Saffron Lodge, 46 Kingsway
Craigweil, Bognor Regis
West Sussex, PO21 4DN

My Ref: AW/344/14/HH-1

11th February 2015

Ref: **OBJECTION : AW/344/14/HH (68 The Drive, Craigweil)**

Job Title
FIRST FLOOR PROPOSED

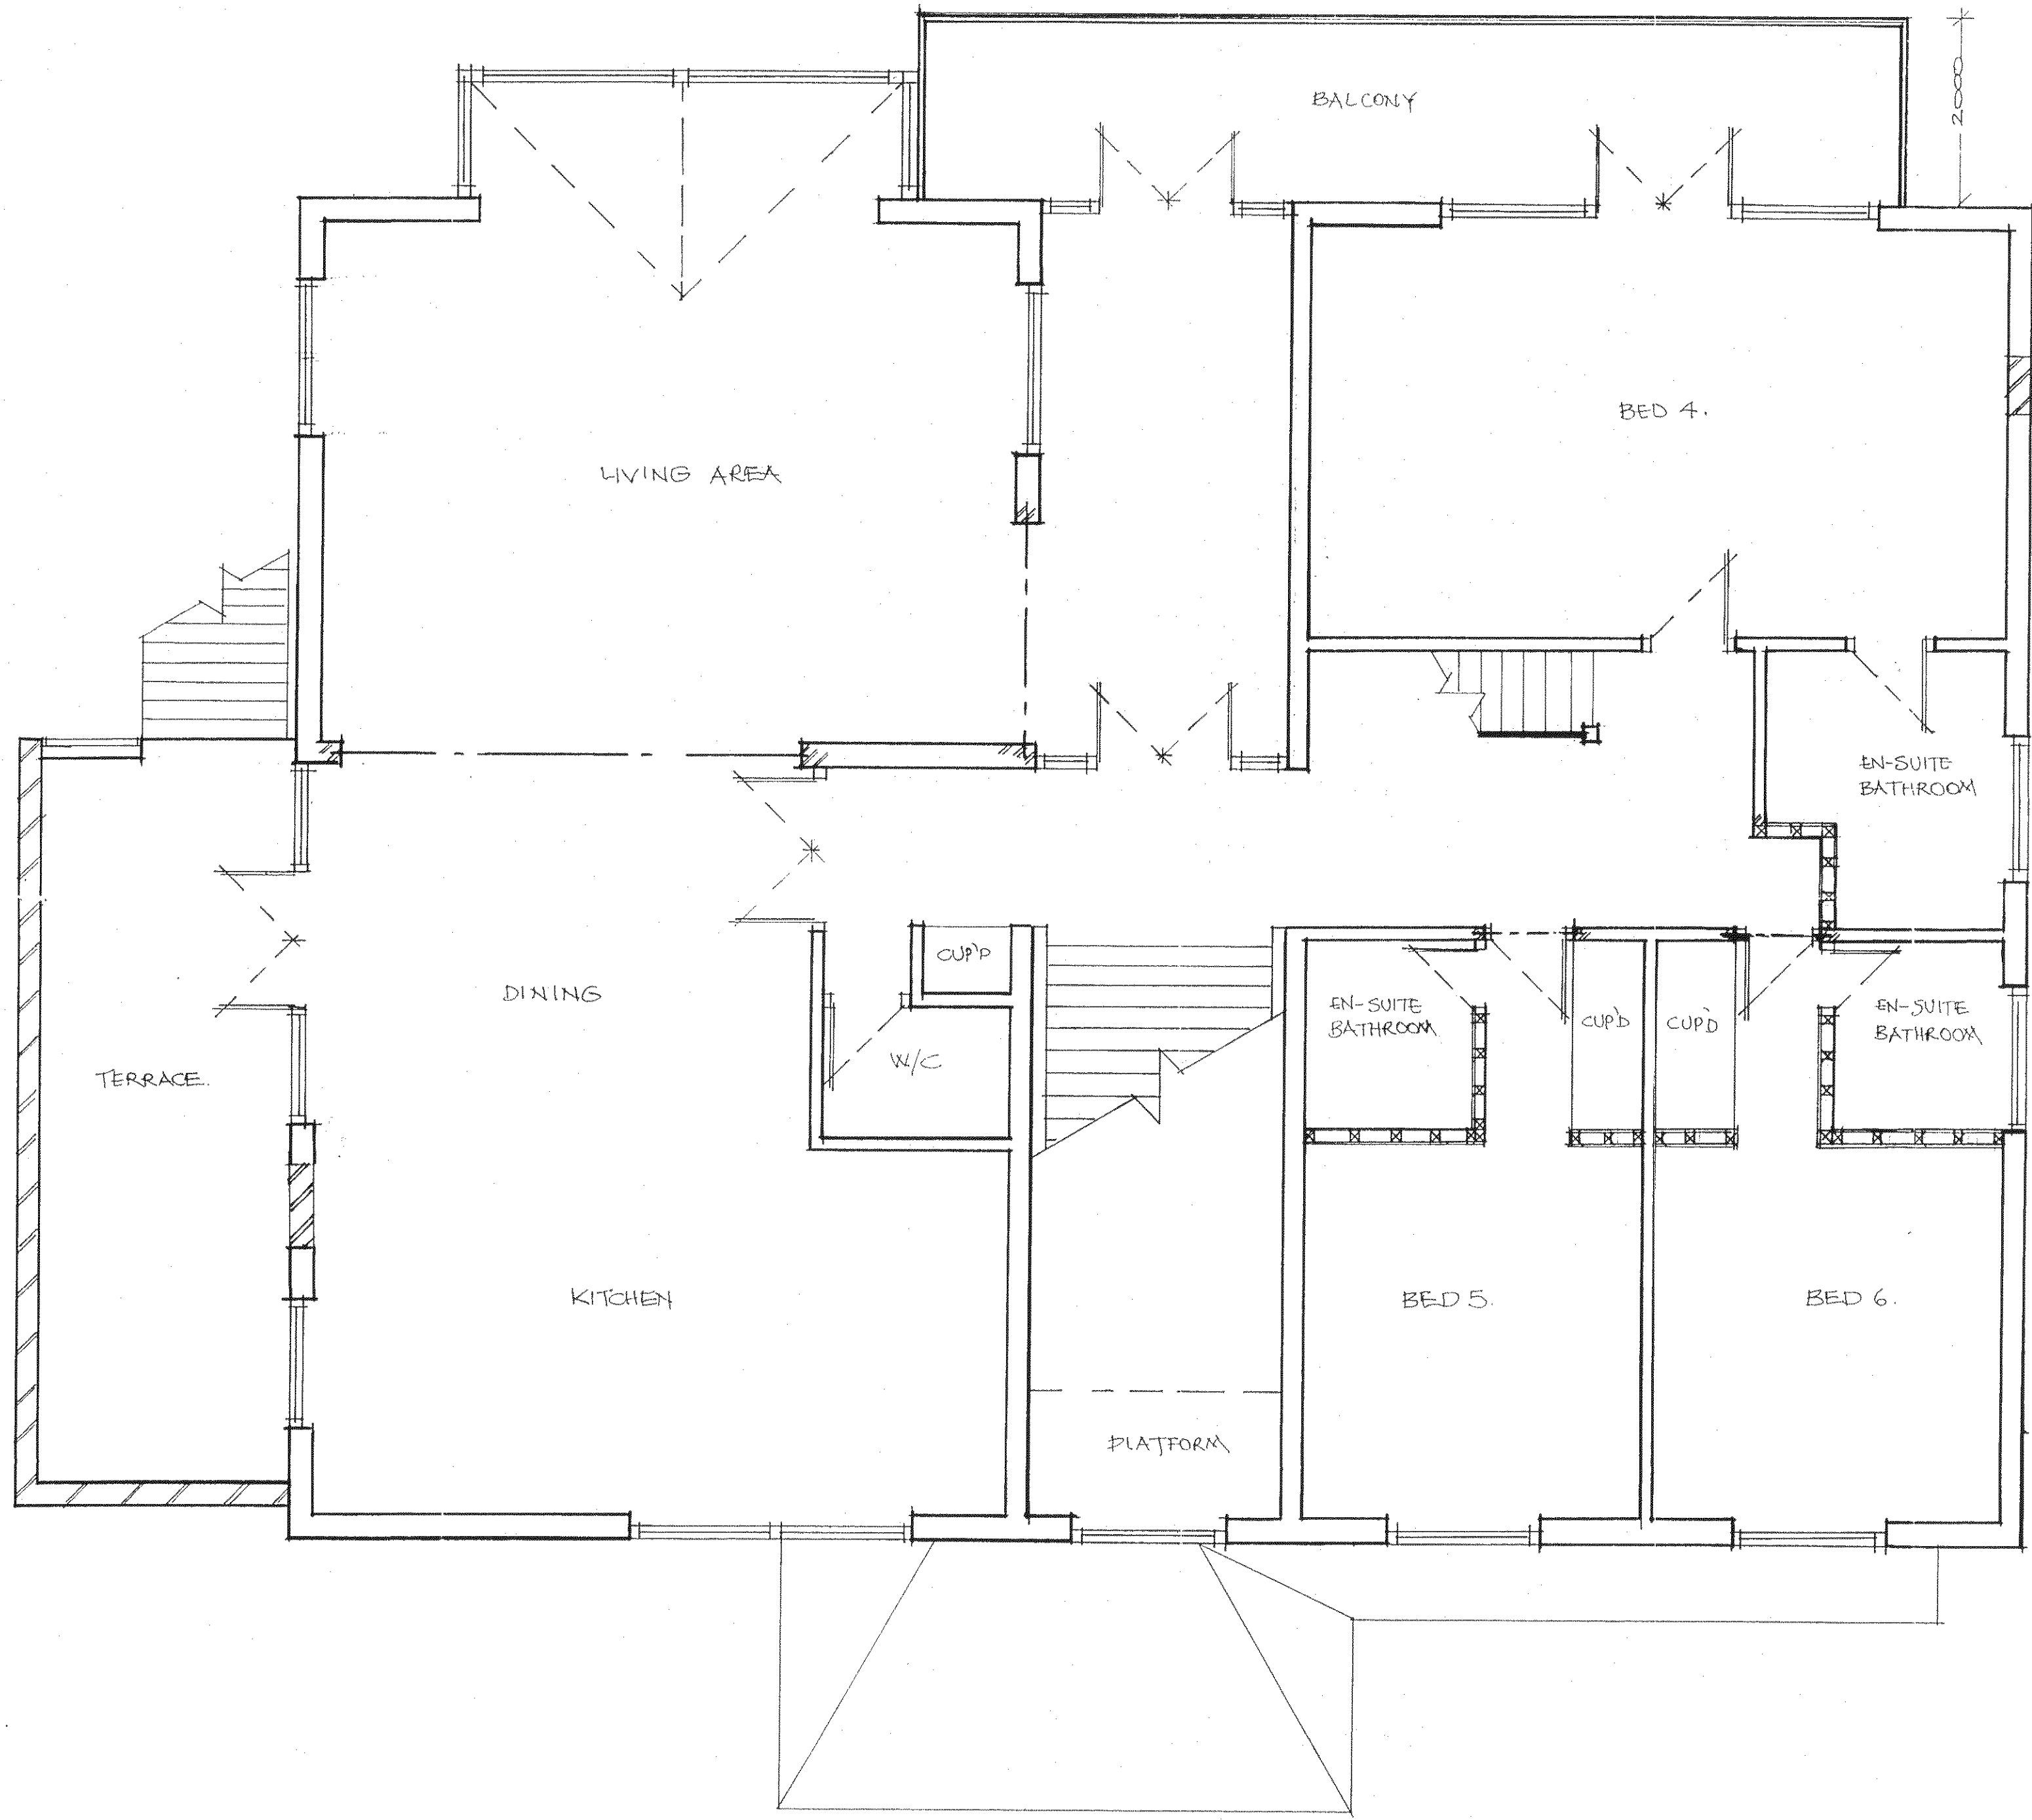
4. In addition, by removing the broad central stairway to the south of the building, access between garden area and the kitchen/dining/communal areas on the 1st floor **will all be by the replacement stairs/terrace** to the east of the building.

6. Not only is the increased footprint of that "terrace" an intrusion upon the neighbour, but the plans indicate (and Mrs Gardner seems not to worry about it) the newly constructed panels to the replacement timber and steel structure are to **CLEAR GLAZING**, which means not only will the neighbour hear intrusive noise, but the adjacent neighbours and their visitors will also be clearly visible at close quarters. The height of the eastern 'terrace' balustrading surely must also **be raised to 2M/6 feet**.
